RE: Administrative Segregations

MEMORANDUM

TO: Phil Rigdon, Deputy Director, DNR
THROUGH: Mel Sampson, YKFP Manager
Pat Spurgin, Legal Policy Analyst
FROM: John Marvin, Habitat Biologist, YKFP
DATE: Tuesday, February 26th, 2013
RE: Kittitas County Administrative Segregations

EASON PROPERTY

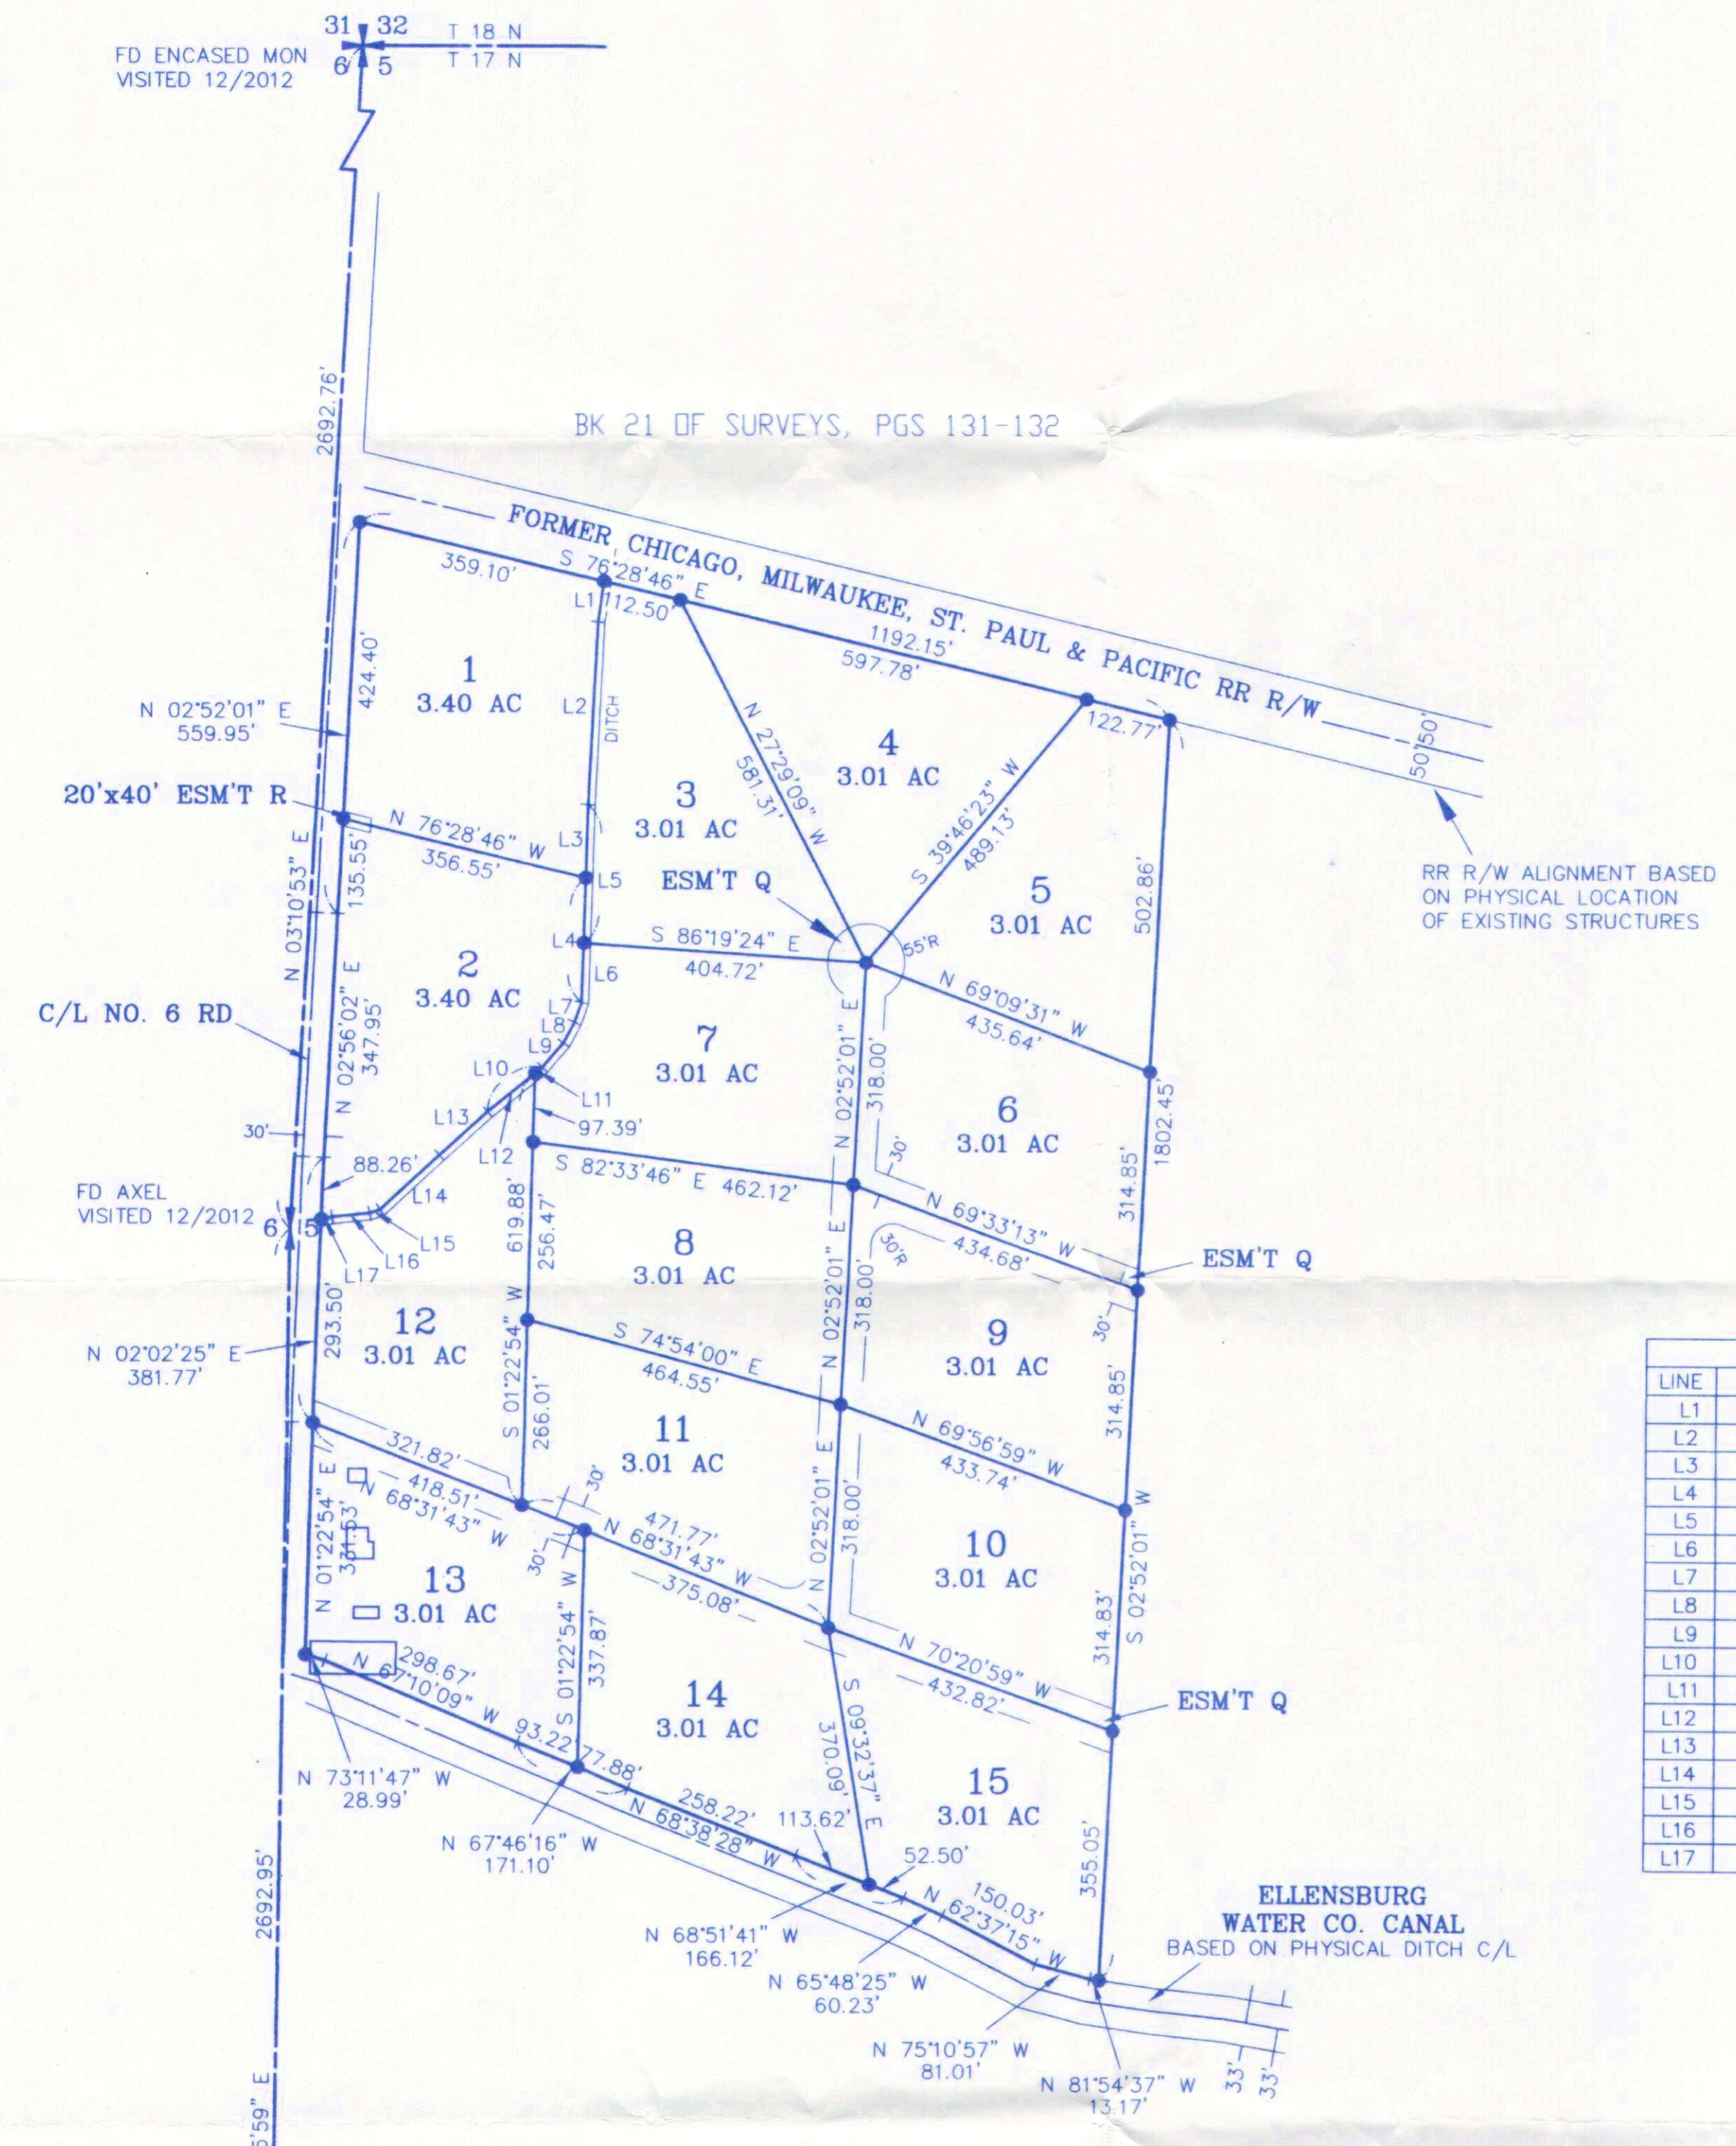
SG-04-10271 Eason – A confusing mixture of boundary line adjustments and segregations to create what looks like 15, 3-acre lots in the Agriculture 20 zone. Even under current county interpretation of SEPA, this application would require SEPA review. It appears that 15, 3-acre lots are inconsistent with zoning and the comprehensive plan. The application requires a determination of adequacy for potable water. The proposed segregation is not consistent with

the protection of water resources due to an increased the risk of groundwater resource development demands by property purchasers.
